Development Facilitation Team (DFT) – Review Comments

Project No: PR-2024-010705 Date: 6/25/2025 Agenda Item: #4 Zone Atlas Page: L-21

Request: Combine Lots 1-10 and 27-34 and the Southerly portions of lots 35 & 36 into one tract.

Application For: MINOR_PLT-2025-00029 – MINOR PRELIMINARY/FINAL PLAT

SHEET 1 OF 2
TERRA PROJECT NO. 2023-153

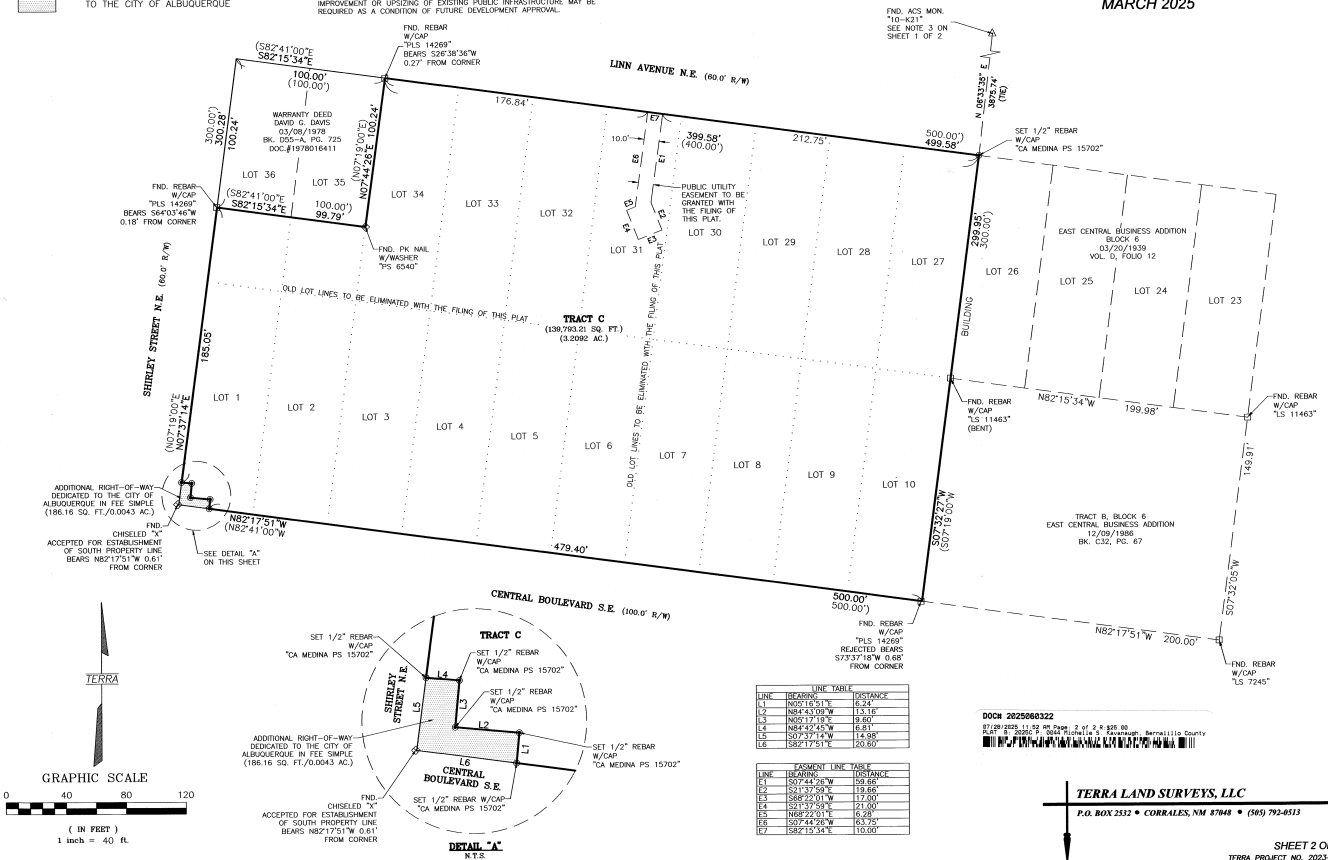
1. Please add the following note to the plat:

- a. “Existing public water and/or sanitary sewer infrastructure may not be constructed or sized to adequately serve potential future development. Improvement or upsizing of existing public infrastructure may be required as a condition of future development approval.”

- Application number must be added to the Plat.
- Planning staff rely on other DFT members to confirm whether any additional public infrastructure needs a financial guarantee.

- Planning staff defer to Transportation regarding the determination requests compliance with the DPM.
- A note must be added to the Plat, which records the requests (approvals) of these determinations from the DHO.
- Signatures from Hydrology, ABCWUA, and Transportation engineers and staff have been obtained on Form PLT.
